1036 Forest Av

146-A-24

1/14/02 - New Sign has been installed

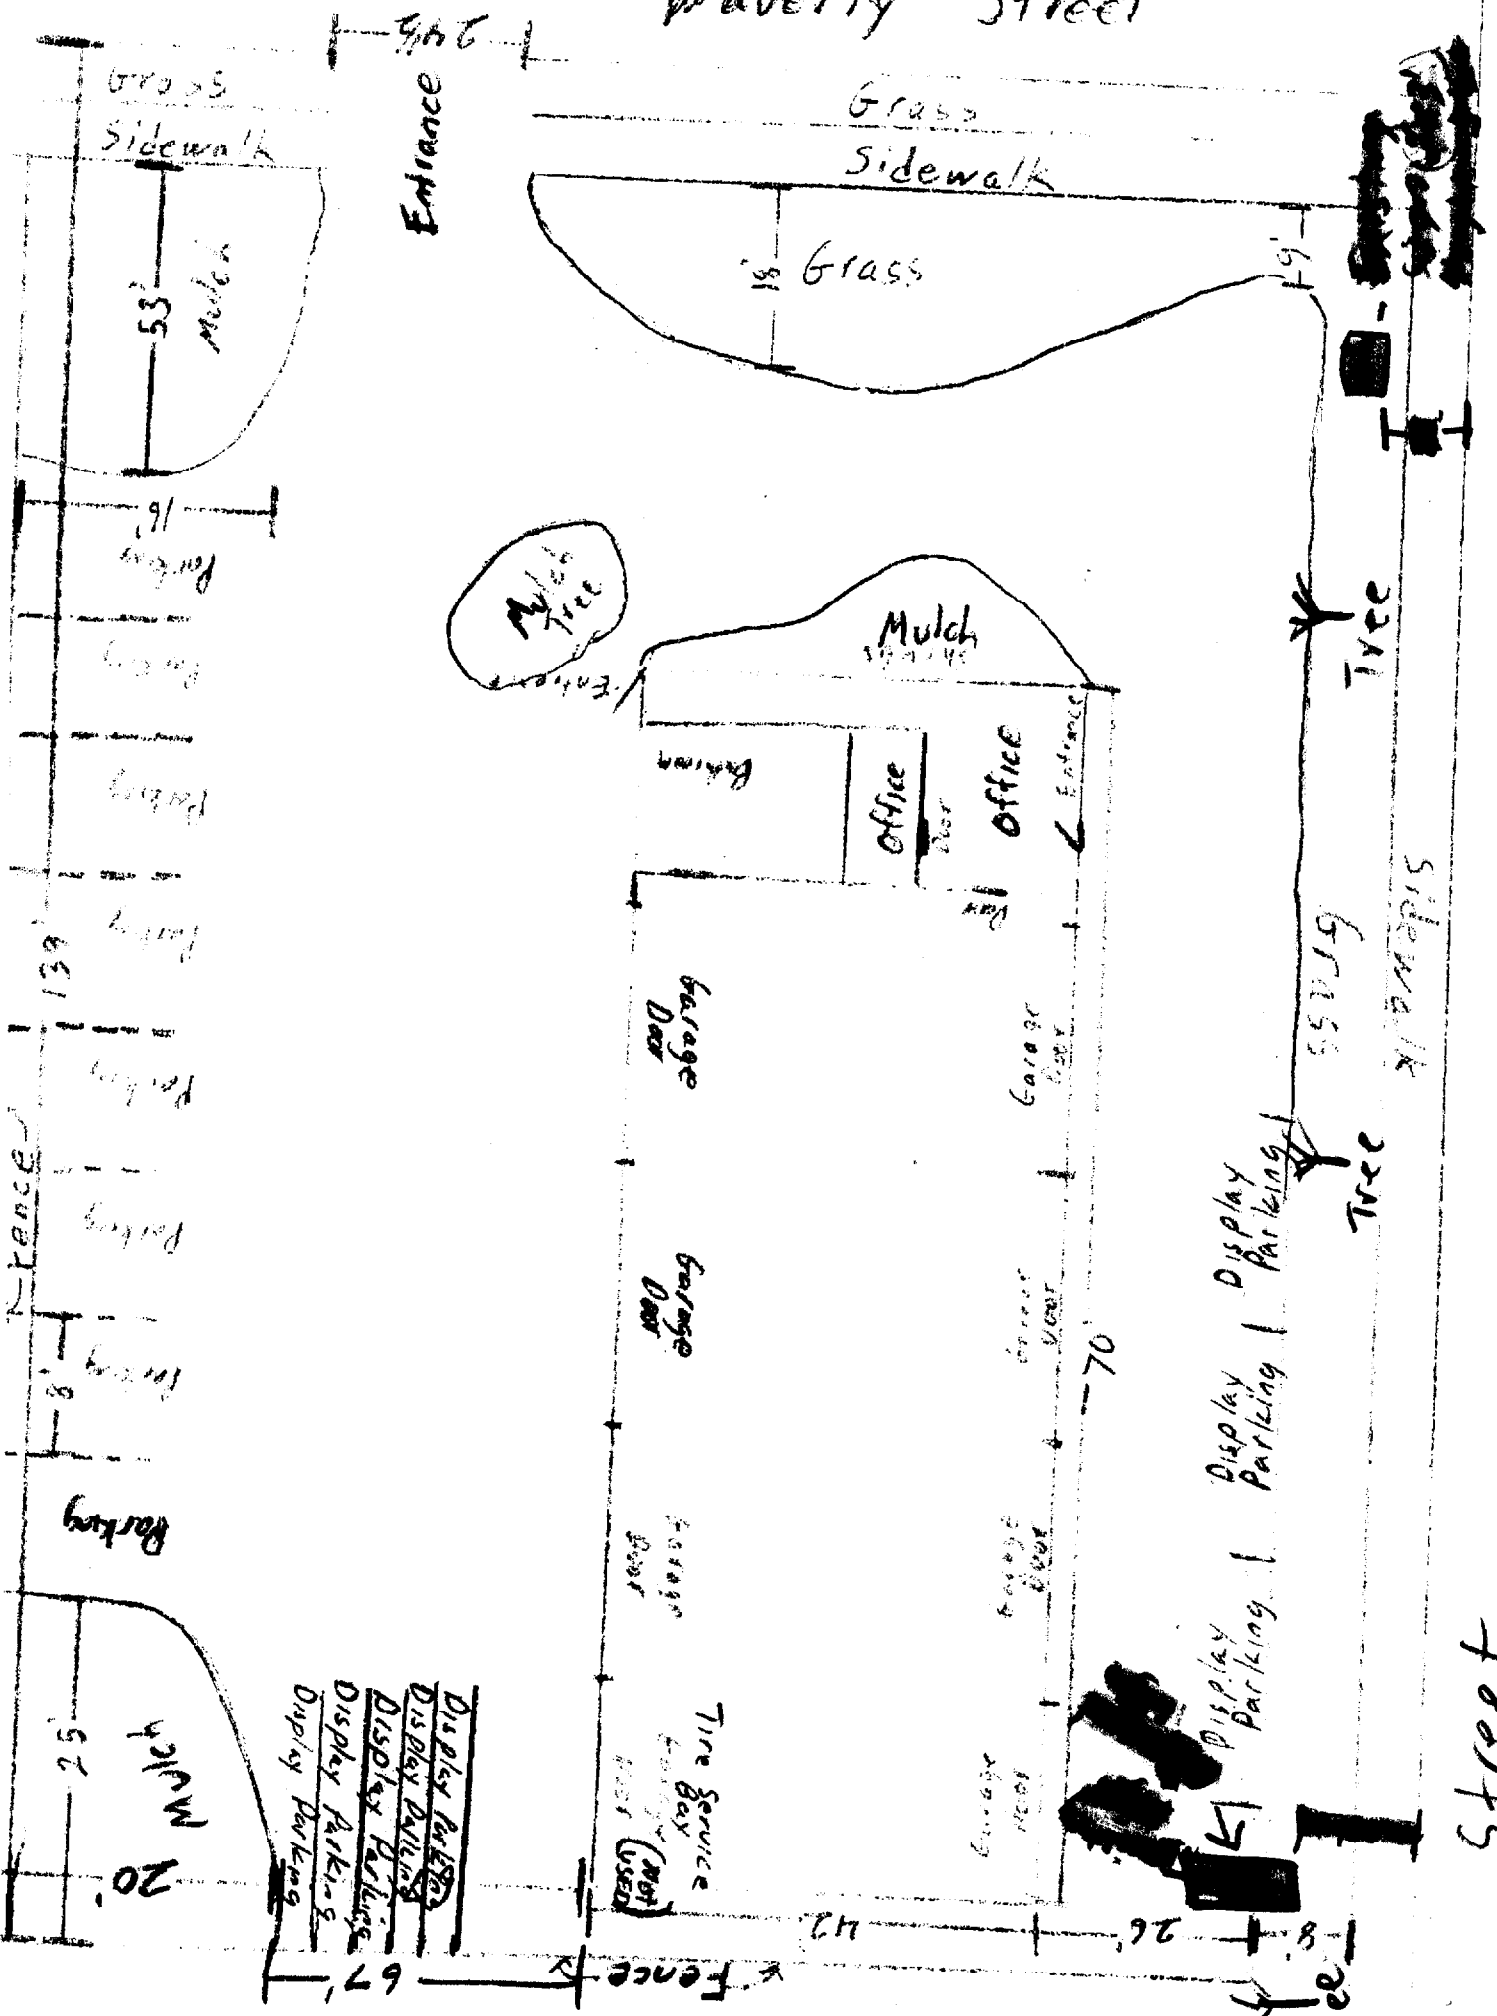
a per specs. - Question on Setbacks -

1- it is replacing existing (I pointed out the 1' off,

2- the new sign is still shorter than the  
main free standing sign & remains within  
the owners defensed property line (fence line)

so it is ok
